Our Ref: FP/79/19/HH

Town & Country Planning Act 1990 (as amended)
Town & country Planning (Development Management Procedure) (England) Order 2015
Application for Planning Permission for Works or Extension to a Dwelling

Development single storey rear extension, lean-to garage, window alterations and new roof coverings

Location 1 Wick Lane Felpham

Location Plan 1 : 1250

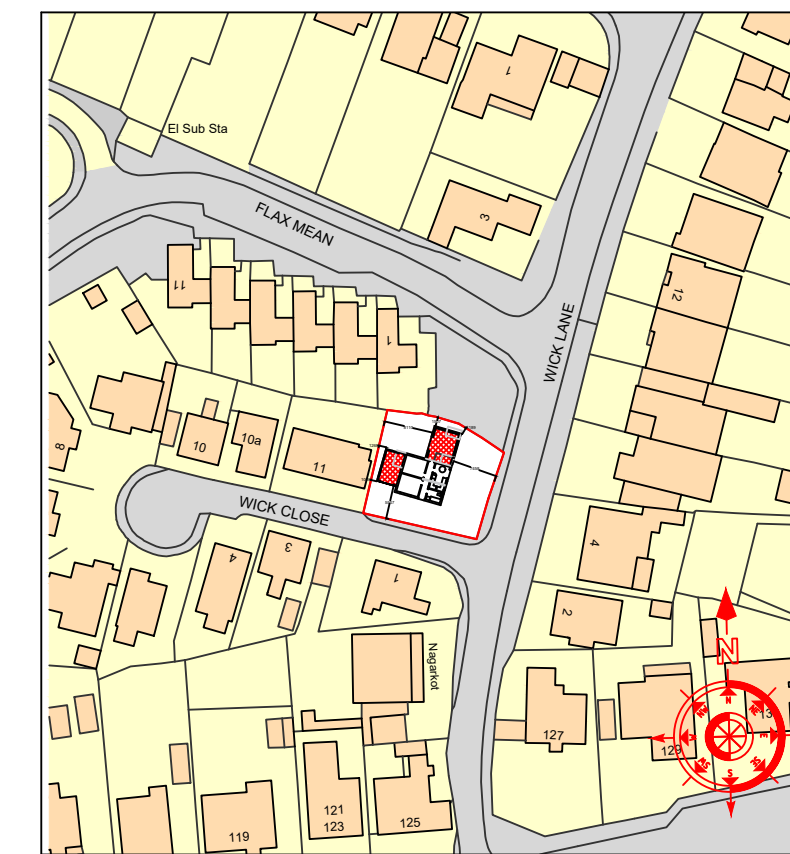
Location Plan: Please remove all other red outlines on the location plan which are not the application outline.

Pedestrian Access: You have answered that there is a new pedestrian access to the site however the plans do not show this. Please confirm whether this is correct and show on plans. However if this is incorrect with your permission we can remove it from your forms for you.

Block plan 1 : 500

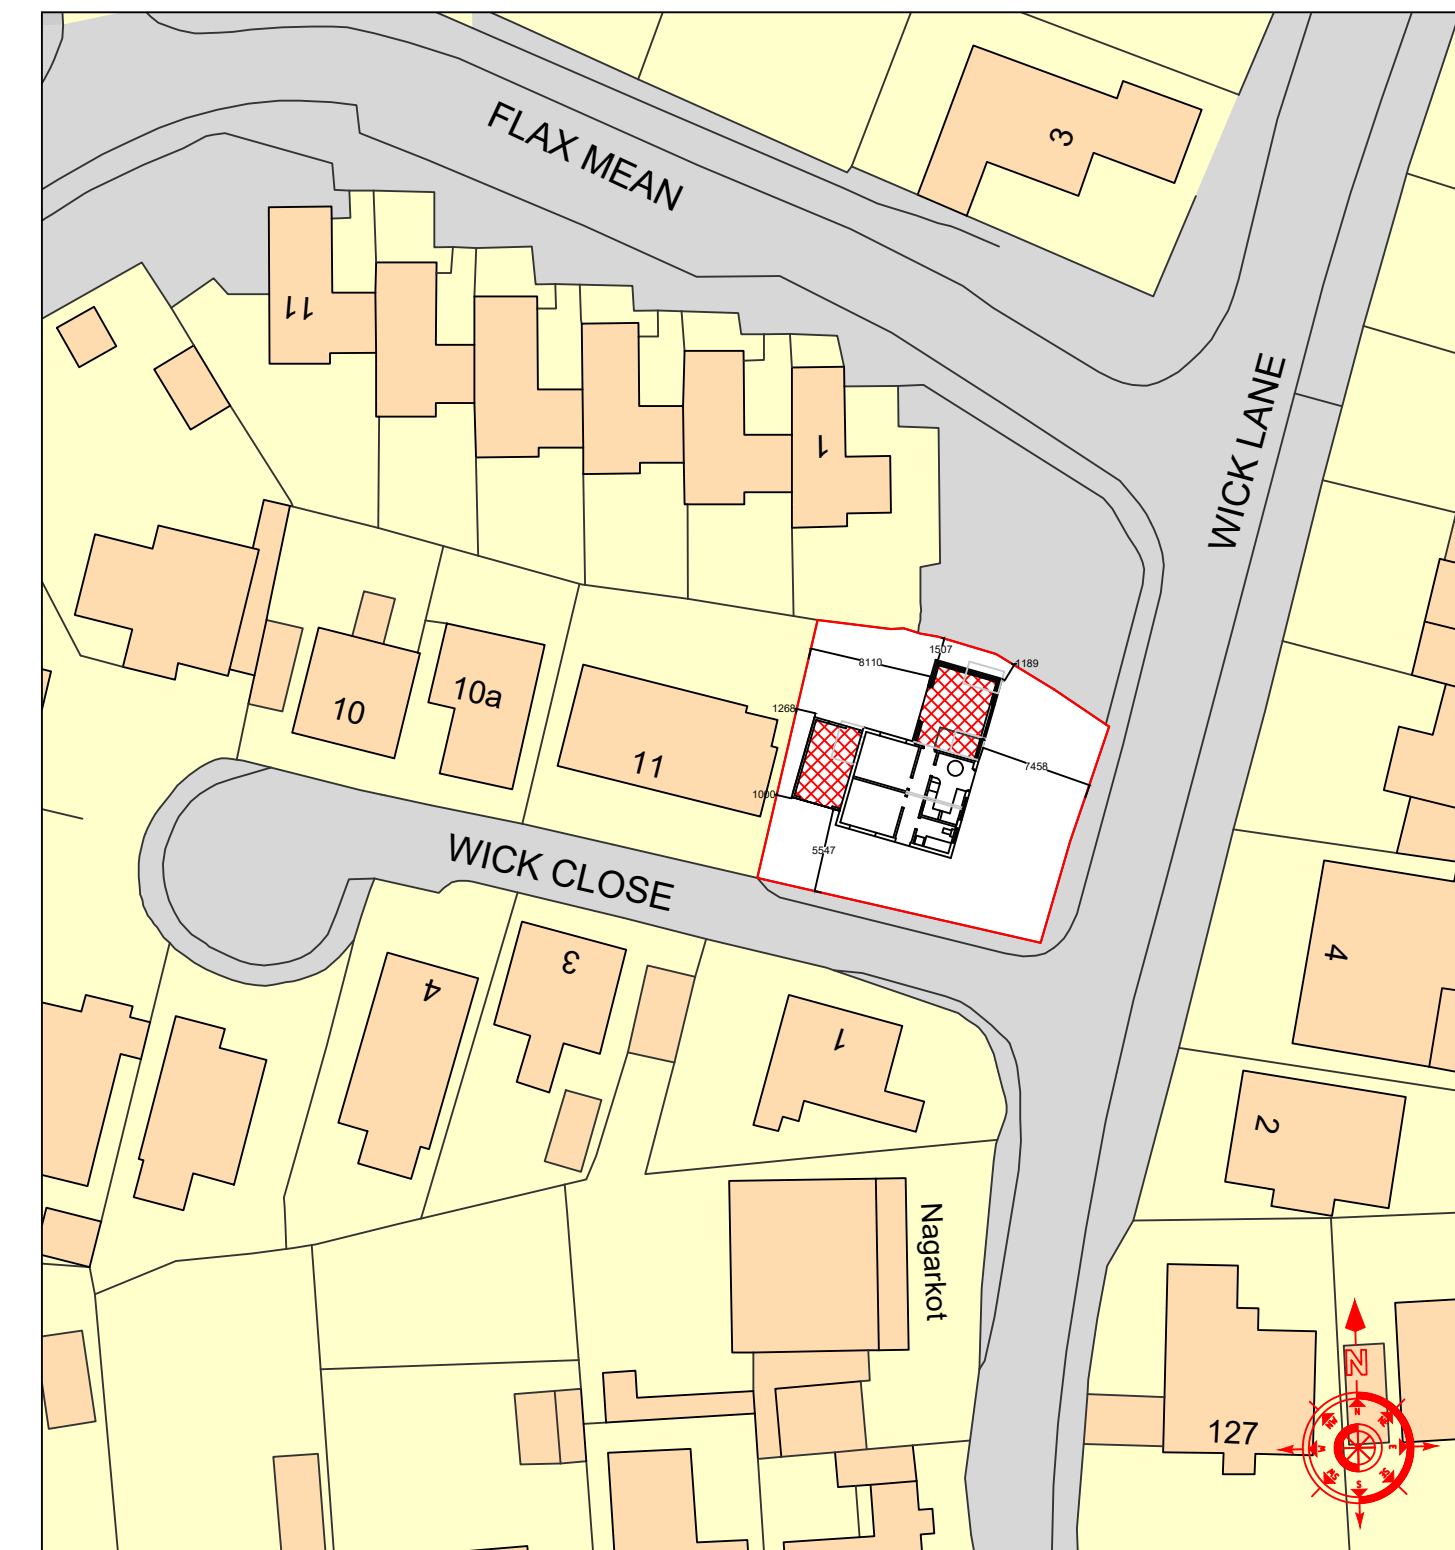
Block Plan

Please submit 1 electronic or 3 paper copies of a block/site plan which includes all dimensions from the proposed extension to the site boundaries.
